To: Albuquerque Planning Department                      From: Jack Ammerman, Project Manager,  
Stantec

**Reference: Westpointe Data Center – Response to DFT Comments  
PR-2020-004747 – Project Number  
SI-2024-00451 – Site Plan DFT**

This provides a response to review comments received April 17, 2024, from the Albuquerque Planning Department on 10 MW Data Center located at Daytona Rd NW between 94<sup>th</sup> St NW and 90<sup>th</sup> St NW.

PROJECT NO.: 193806697  
DWN BY: HKK    CHKD BY: JRA    APPD BY: CMR  
ISSUE DATE: 08/01/2024  
ISSUE NO.: 5  
SHEET TITLE: SITE PLAN  
SHEET NO.: C-101

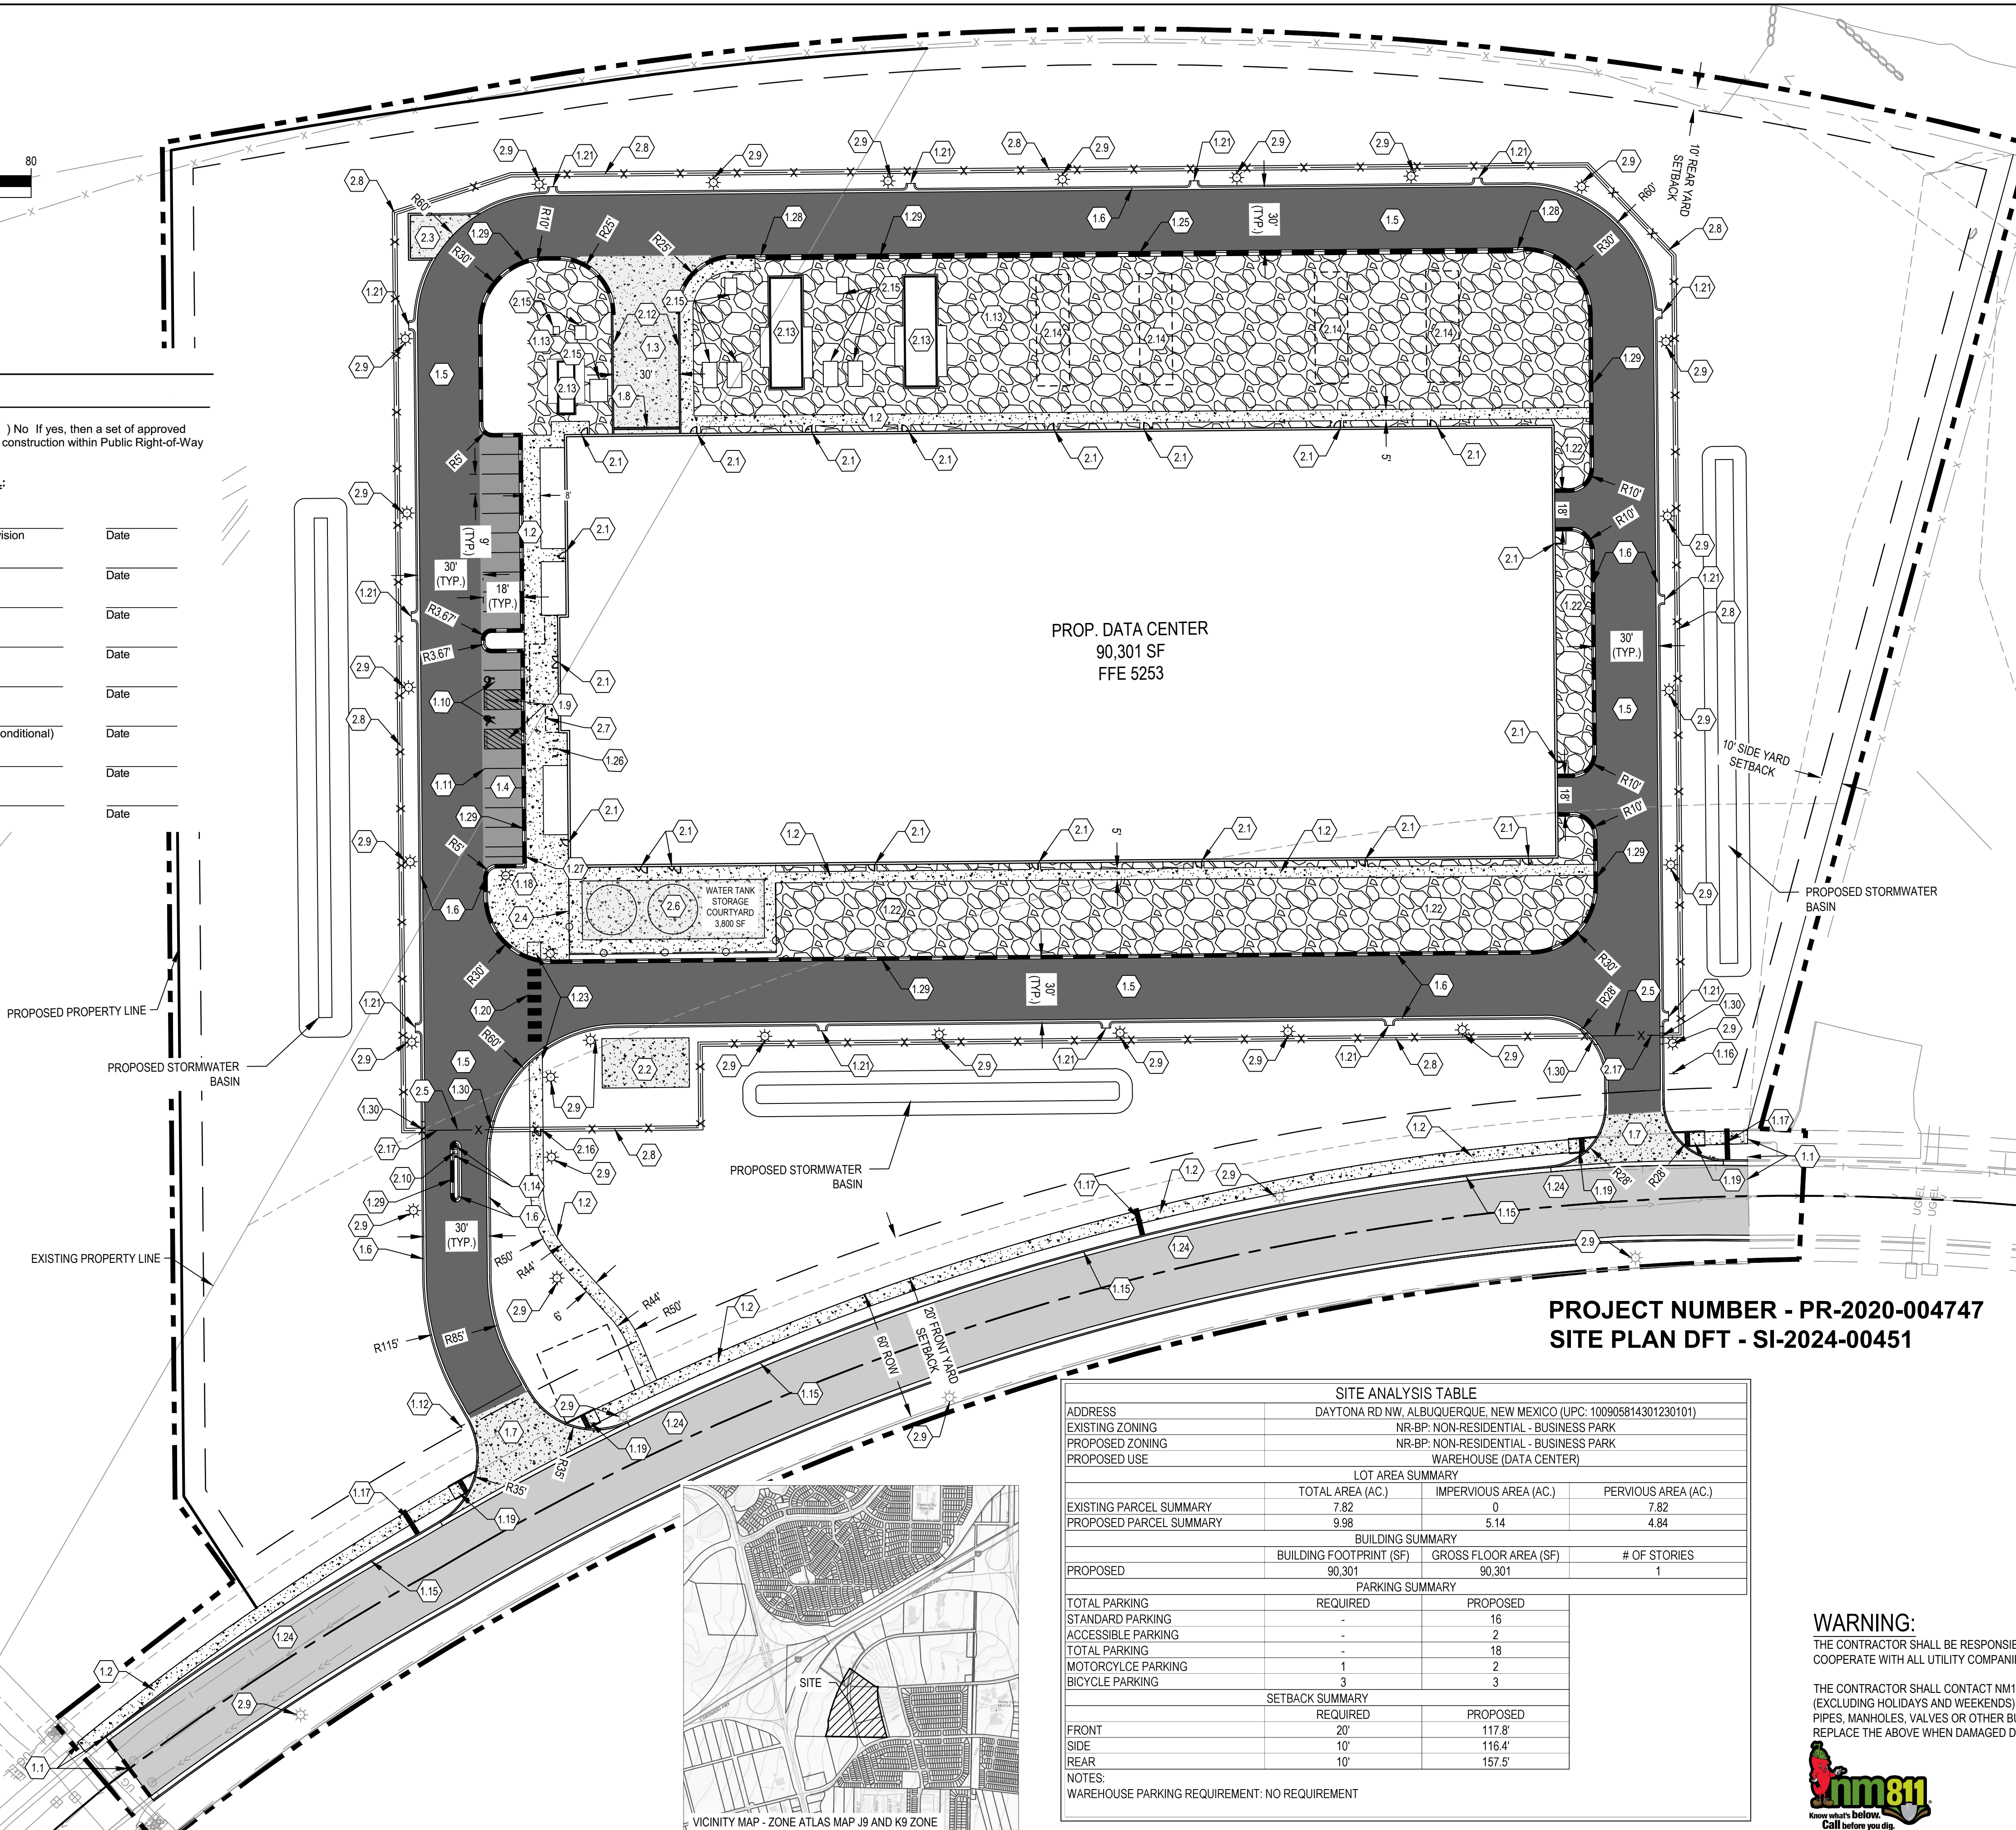
- 3. Please clarify types of use proposed for calculation of parking. Site Plan and application indicate Office use and data center. Justification letter shows it as Warehouse. Please determine correct use as defined by the IDO.**

- 4. Parking must meet all requirements of IDO 5-5, Table 5-5-1. Must show amount of floor area dedicated to each respective use, parking requirements for that use, and total required parking calculations based on areas of use.**

- 7. The project and application numbers must be added to cover sheet (preferably to the Site Plan sheet), prior to final sign-off from Planning.**

*Per City feedback at the pre-app meeting the use will be classified as Warehouse, which has no minimum parking requirements per the IDO. The plans have been updated to reflect this use and parking requirement.*

*Per City feedback at the pre-app meeting the use will be classified as Warehouse, which has no minimum parking requirements per the IDO. The plans have been updated to reflect this use and parking requirement.*

*The plans have been revised to include the project number and application number on the Cover Sheet and Site Plan.*

OVERALL PLANTS AND MATERIAL SCHEDULE

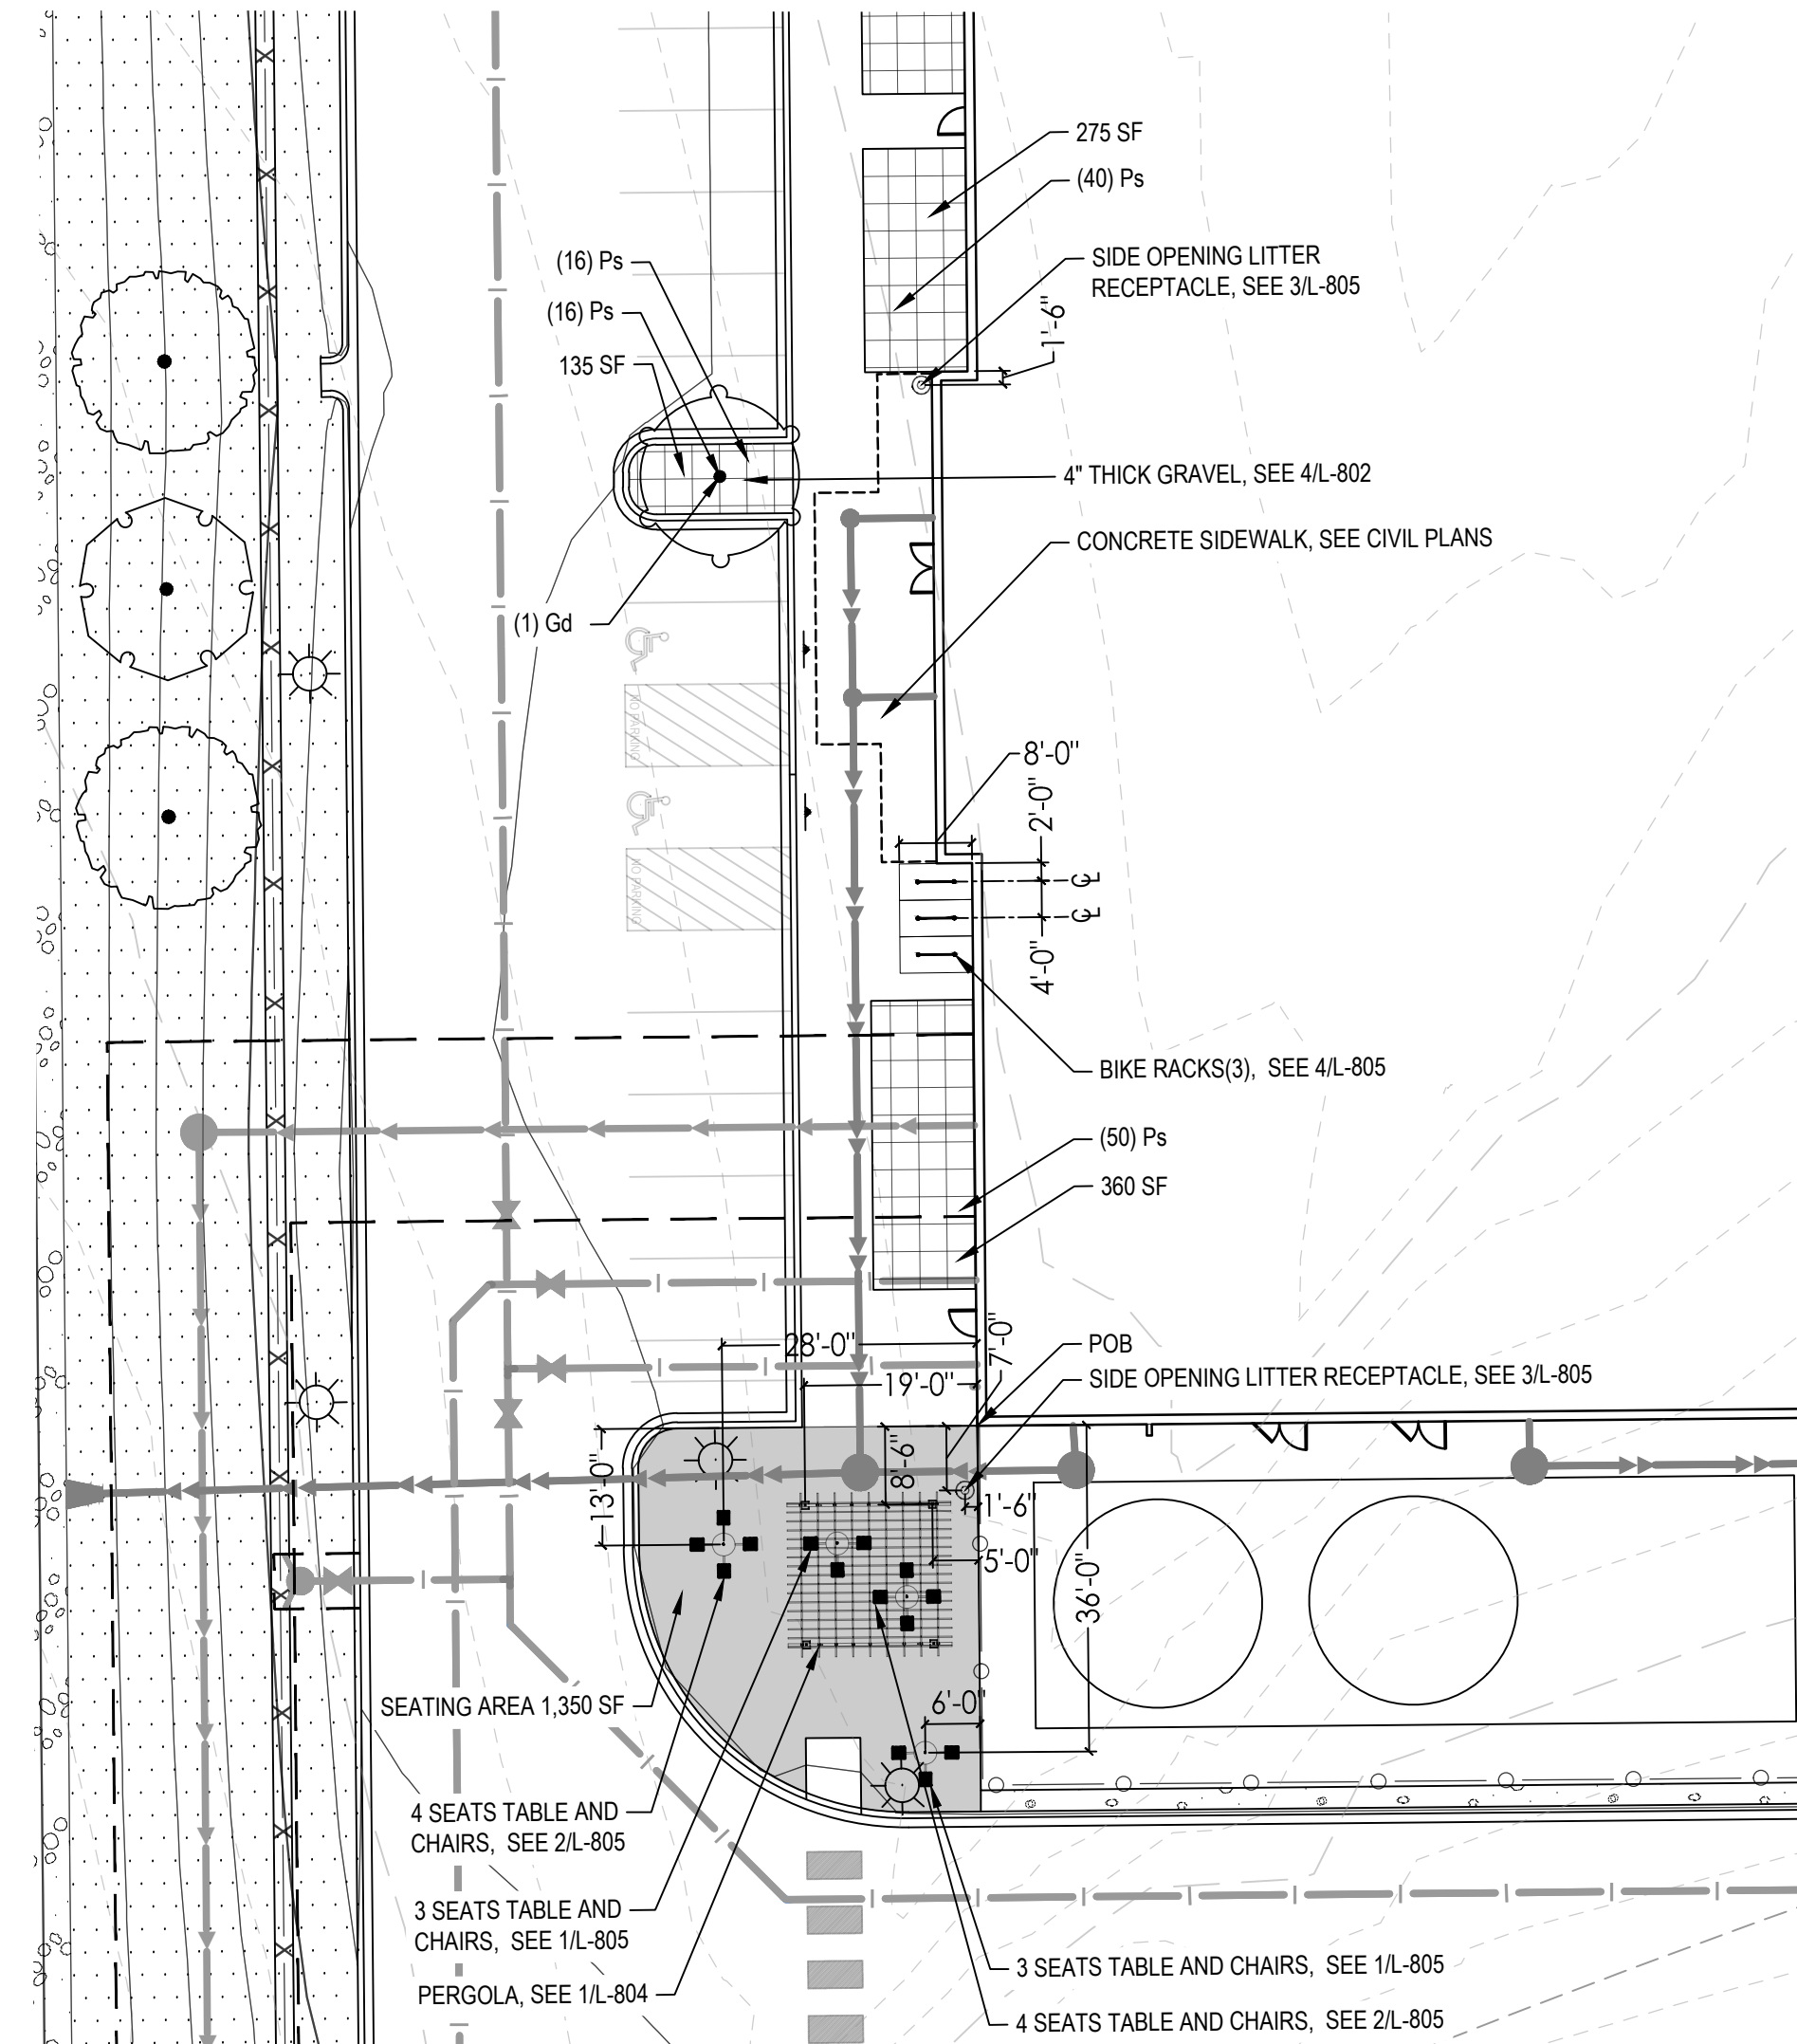
- 6. Need to provide Landscaping plan meeting requirements of IDO 5-6, with calculations shown for percent of net lot area, percent of coverage, number of street trees, and all other applicable requirements.**

- Please explain why some areas of the site been left empty without landscaping. Add landscaping to the frontage of the site. Please see the marked-up image below for your reference:**

4. Along the rear stretch of the site, add large evergreen desert shrubs to enhance the provided tree buffer from Interstate 40. See the marked-up image below for your reference:

5. Please add trees to provide shade for the ponding area. Consider adding very large tree canopies in these areas. Please see the marked-up image below for your reference.

1. Tree canopies and ground-level plants shall cover a minimum of 75 percent of the total landscape area as measured by canopy width or the area beneath the dripline of the mature size of the actual vegetation. **54,759 sf of landscape coverage is required. Please show correct calculations that provide tree coverage number.**

**2. Of the required vegetative coverage, a minimum of 25 percent shall be provided as ground-level plants (shrubs, grasses, etc.) as measured of the mature size of the actual vegetation. 13,690 sf of ground-level plants is required. Please add more shrubs or groundcovers to comply with this code.**

**Per 5-6(C)(4)(i), shade trees planted approximately 25 feet on-center are required along all required pedestrian walkways. If the walkway is less than 25 feet long, at least one tree is required, or, where there is insufficient space for a tree, a trellis of at least 8 feet high for at least 5 feet along the walkway shall be provided. 35 trees along I40 is proposed. 26 trees long Daytona Rd were counted please explain. Alternate street tree species for the same reason previously mentioned in this memo.**

**Per 5-6(C)(5)(c), the use of gravel or crusher fines as ground cover is limited to a maximum of 75 percent of any landscaped area. Please add proper calculations to demonstrate compliance with this code. Please see 5-6(C)(5)(e) for further information regarding this item. Provide area numbers for landscape materials on material legend.**

*Acknowledged. Sheet L-800 has been included depicting the calculations for landscaping requirements. Calculations have been updated to include recent changes requested via DFT comments.*

*The Landscape Plans have been updated to provide landscaping coverage over the previously empty areas. Trees have been added per City Staff recommendation on the frontage of the site.*

The landscape buffer from I-40 has been revised to provide an increased buffer per coordination with City Staff. Total shrubs for buffer provided are 141. 36 Curlleaf Mountain Mahogany, 35 Chamisa, 35 Apache Plume, 35 Texas ranger to enhance the buffer along the corridor.

The Landscape Plans have been updated to provide additional large trees for pond shading through coordination with City Staff. 12 *Ulmus Parvifolia*, 2 *Quercus Gris*, 2 *Sambucus Mexicana* and 1 *Prosopis Glandulosa* have been added adjacent to the stormwater basins.

*Please see Sheet L-800 for the updated calculations for landscape area coverage for plant canopies.*

*Please see Sheet L-800, Landscape Requirement Table for the updated calculations for vegetative coverage for ground-level plants.*

*The Landscape Plans have been updated to meet the required 30 shade trees along Daytona Road by adding additional trees within the 20' corridor from back of curb. Trees are alternating in species.*

*The Landscape Plans have been updated to show breakdown of ground coverage throughout site on Sheet L-800, Landscape Requirement Table.*
